**Colorado Springs Airport Advisory Commission Meeting
To Be Heard March 28, 2018
Land Use Review Item #02**

EL PASO COUNTY BUCKSLIP NUMBER(S): CS-18-002 COMMERCIAL REZONING		TAX SCHEDULE #(S): 550000135
DESCRIPTION: Request by CPR Entitlement, LLC on behalf of Ranking Holdings LP for approval of the Springs East at Waterview rezone from A-5 (Agricultural) to CS (Commercial Services) for Parcel P-17 identified on the Waterview Sketch Plan. The property consists of 26.64 acres and is located southeast of the intersection of Bradley Road and Powers Boulevard. <i>Review Note: The Springs East at Waterview preliminary plan and commercial development for this property was reviewed and approved by the Commission in February 2018.</i>		
CONSTRUCTION/ALTERATION OF MORE THAN 200 FEET ABOVE GROUND LEVEL? No	DISTANCE/DIRECTION FROM COS: 4,900 feet south of Rwy 35R	
TOTAL STRUCTURE HEIGHT AT THE ESTIMATED HIGHEST POINT: 45 feet above ground level; 6,045 feet above mean sea level	COMMERCIAL AIRPORT OVERLAY SUBZONES PENETRATED: Accident Potential Zone 1 (APZ-1); Accident Potential Zone (APZ-2)

# WATERVIEW EAST - COMMERCIAL SITE ZONING MAP

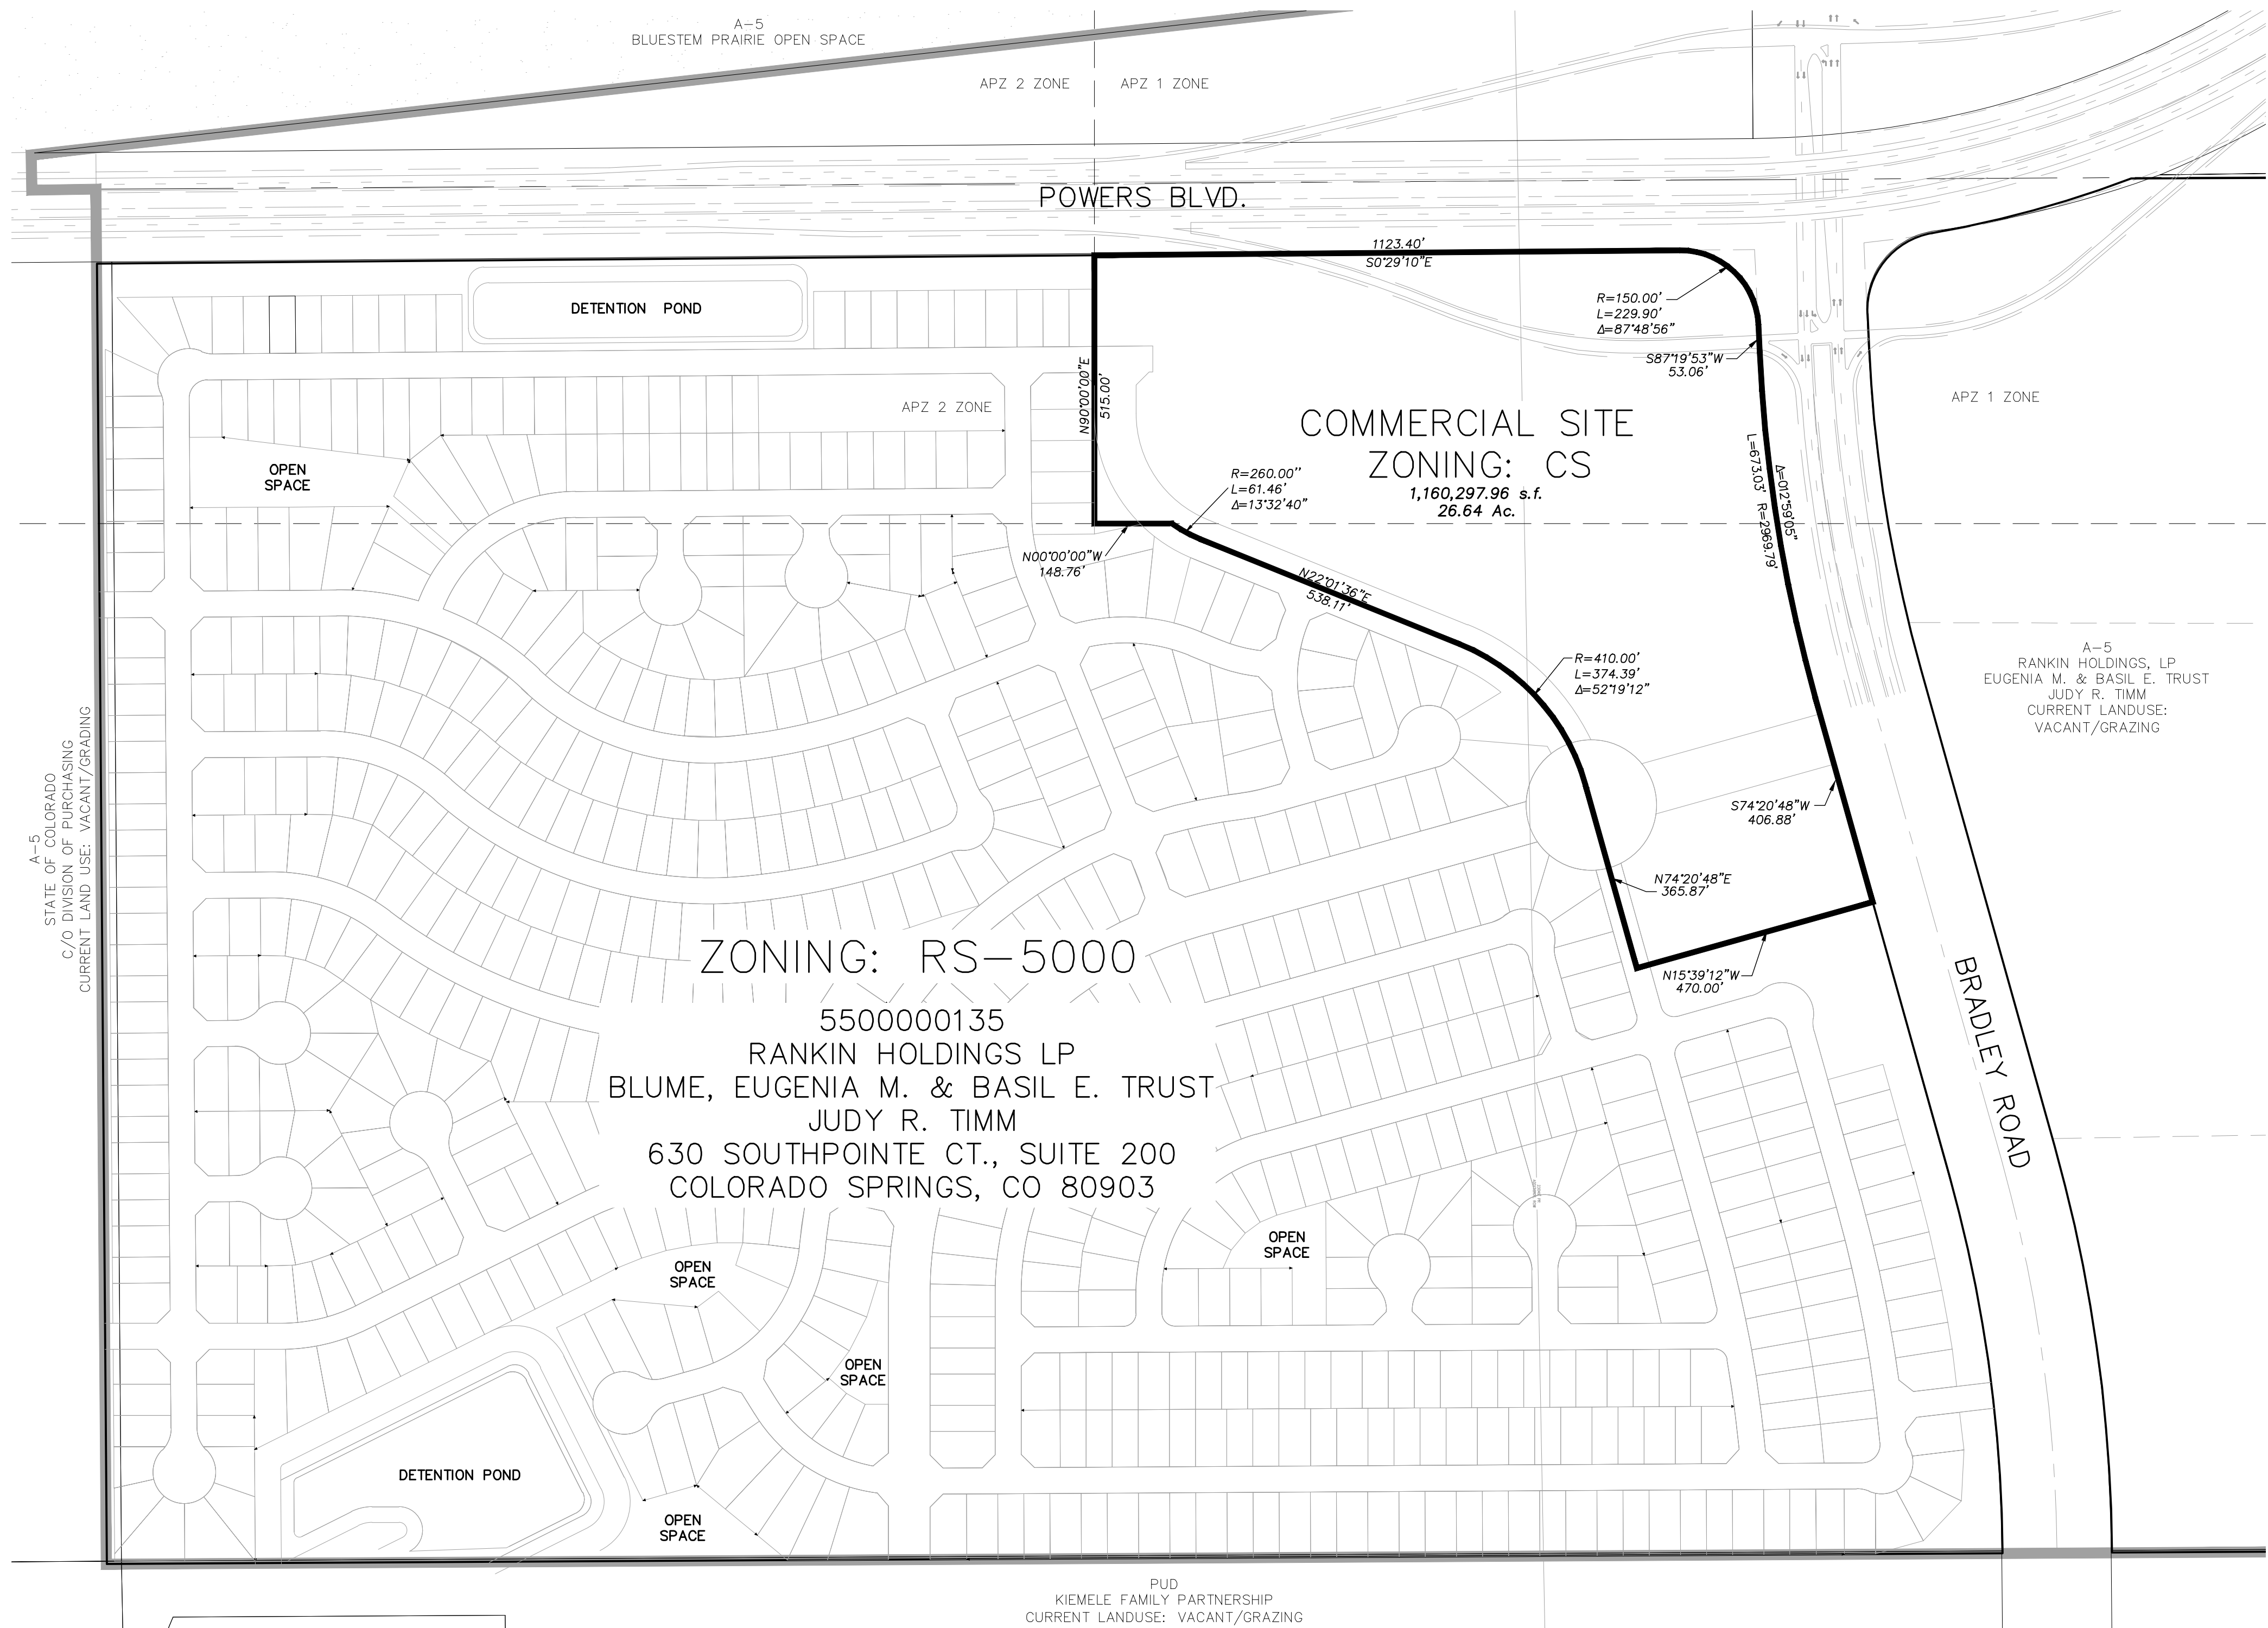
- Due to this development encroachment on the airport, the AAC recommends the developer work with airport staff to create mechanisms for communicating aviation impacts within deeds of land development.

- An Avigation Easement or proof of previous filing (book/page or reception number) is required.
- The proposed development is within the Accident Potential Zone 1 (APZ-1) subzone of the Commercial Airport Overlay District, as adopted by El Paso County. Commercial development is permissible in the APZ-1 subzone.

- The proposed development is within the Accident Potential Zone 2 (APZ-2) subzone of the Commercial Airport Overlay District, as adopted by El Paso County. Commercial development is permissible in the APZ-2 subzone.

- Based on elevation data, the applicant will need to file Federal Aviation Administration (FAA) Form 7460-1 "Notice of Proposed Construction or Alteration" for any new vertical development at this site, including temporary construction equipment, and provide FAA documentation to the Airport before the commencement of construction activities.
